**CITY OF ALBUQUERQUE
PLANNING DEPARTMENT
September 29, 2004
DRB Comments**

PROJECT # 1003293

RE: Tract F-7-A, Atrisco Business Park, Unit 3/SPBP

**TRACT F-7-A, ATRISCO BUSINESS PARK
 GRADING AND DRAINAGE PLAN**

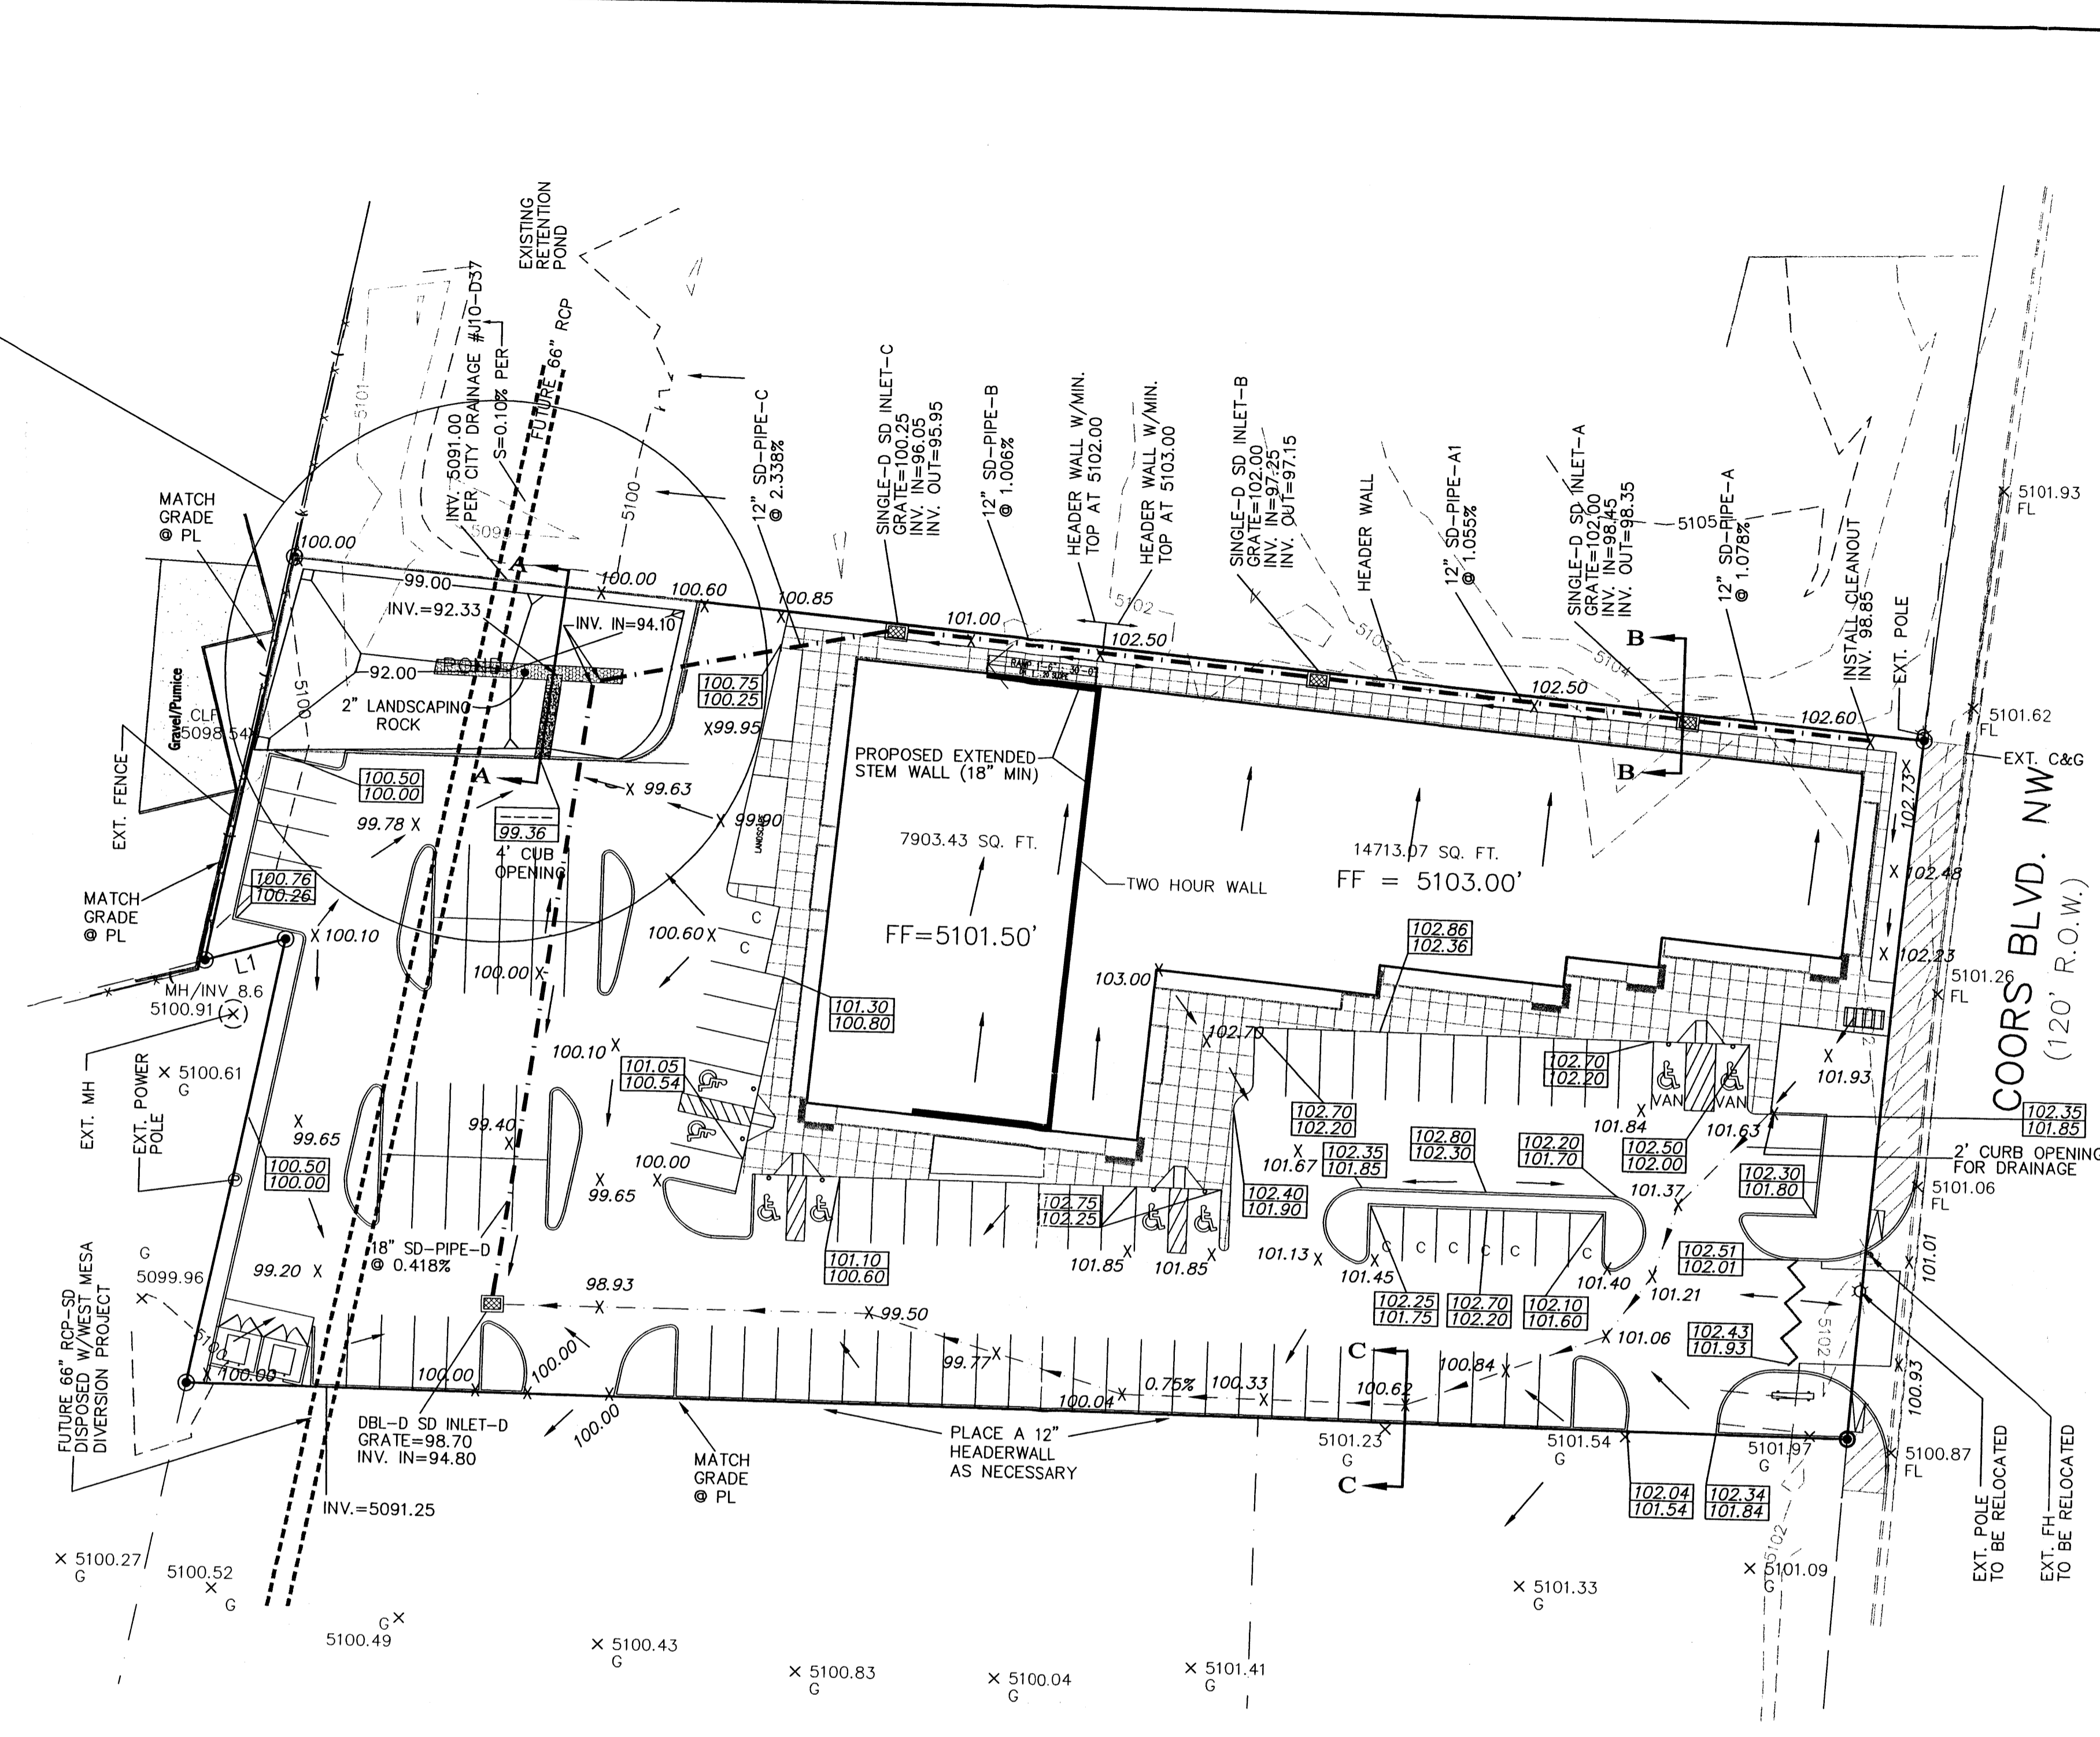
Need to relocate dumpster out of drainage easement or at least out of the proposed pipe alignment.
